**ADDENDUM 2**  
To Contract Documents for  
**EYECARE MEDICAL GROUP**  
53 SEWALL STREET  
PORTLAND, ME 04102

**E.M.G. - Phase 2 Addition & Renovation**

EYECARE MEDICAL GROUP  
PHASE 2 ADDITION AND RENOVATION  
ADDENDUM NO. 2  
July 15, 2013

A5 Waiting Room East
1/4" = 1'-0"

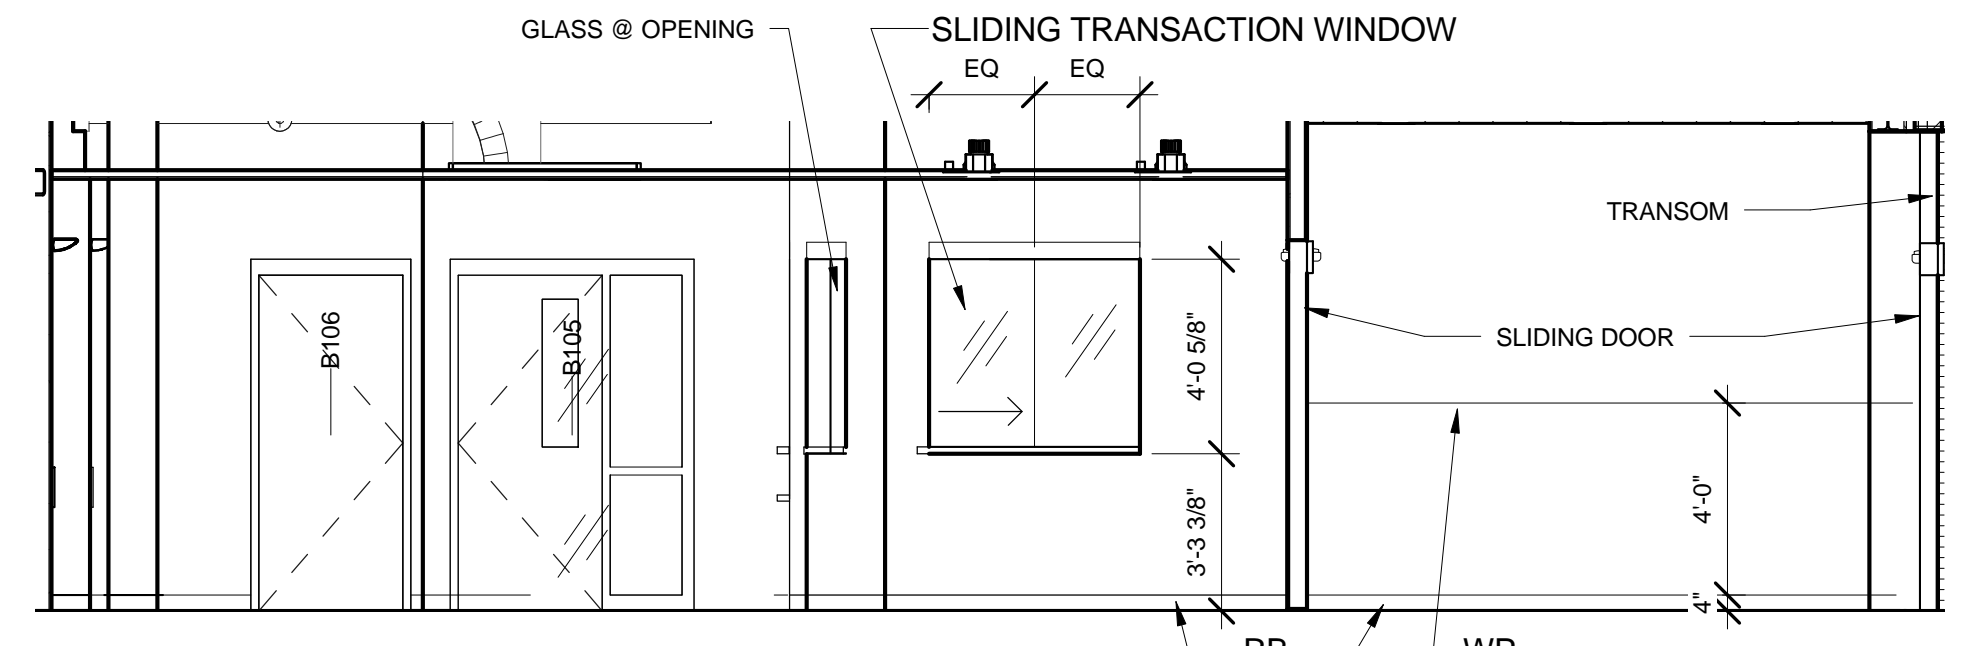
- 1.** ADD soffits in Autoclave B119 as indicated on SKA-1.
- 2.** ADD soffits in Nurse B108 as indicated on SKA-2.
- 3.** REPLACE elevation A5/A201 with SKA-3, clarifying wall lighting layout.
